**Re: Gibson Shops-1400 Gibson SE
Erosion and Sediment Control Plan
Engineer's Stamp Date 3-14-18 (L15E049)**

Based upon the information provided in your submittal received 3-22-18, the above referenced plan is approved to be included in the SWPPP and to apply for an ESC permit for grading and Building Permit with the following condition:

FAMILY DOLLAR STORE			
EROSION & SEDIMENT CONTROL PLAN			
MARK GOODWIN & ASSOCIATES, P.A. CONSULTING ENGINEERS P.O. BOX 90606 ALBUQUERQUE, NEW MEXICO 87199 (505)828-2200, FAX (505)797-9539			
Designed: DMG	Drawn: DER	Checked: DMG	Sheet 1 of 1
Scale: 1" = 30'	Date: 11/10/17	Job: A16075

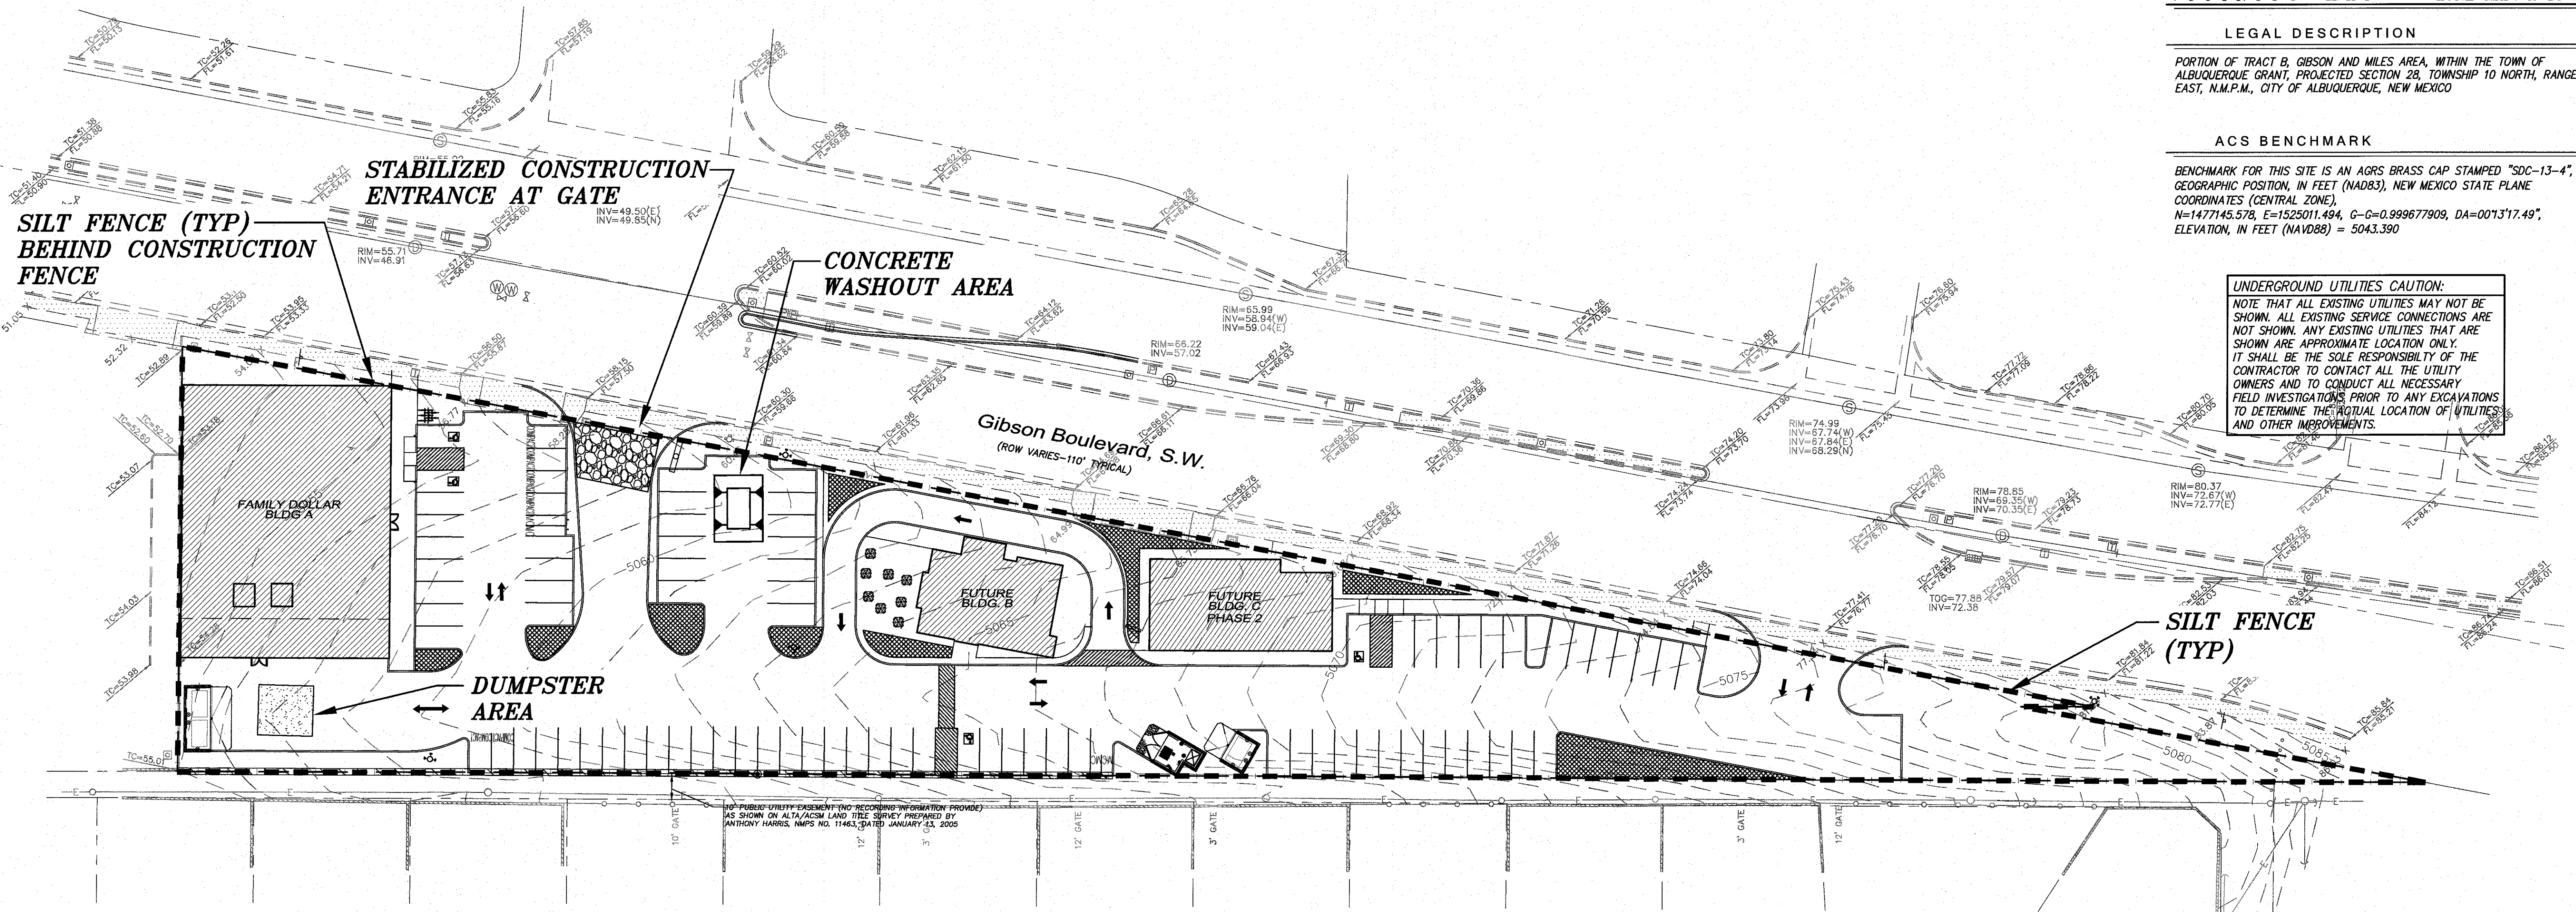
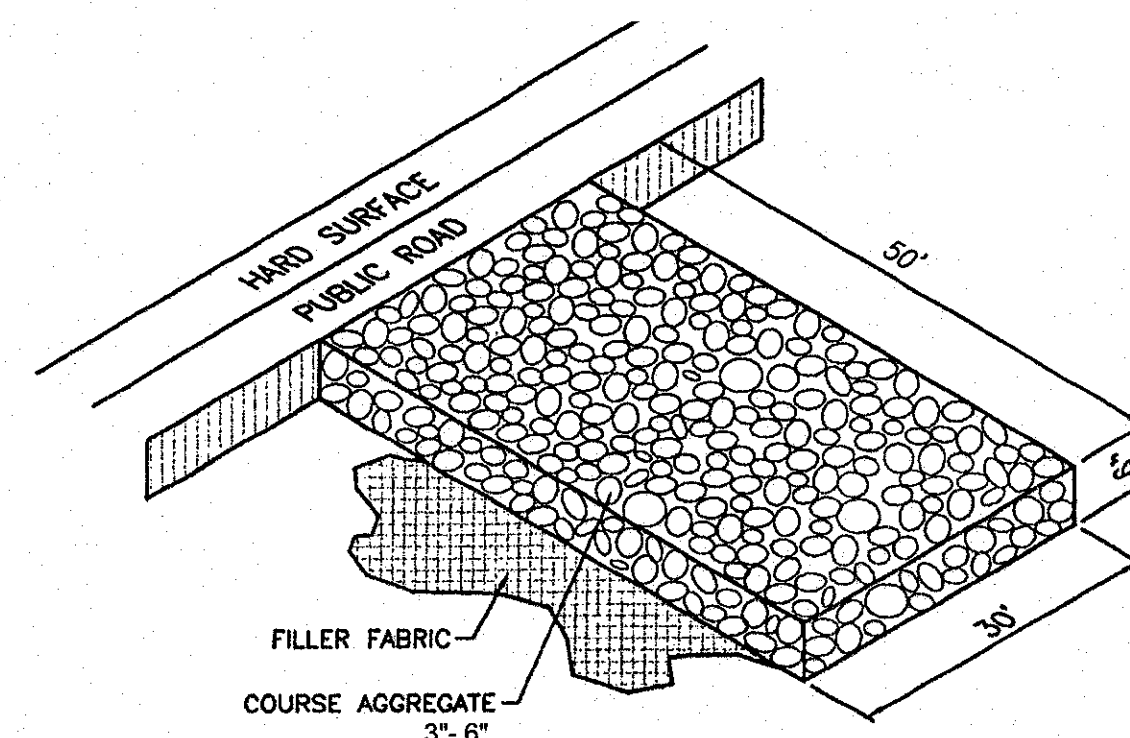
1. Vehicle Tracking Control will have to be relocated from Gibson Blvd to the buildings under construction at the appropriate time.
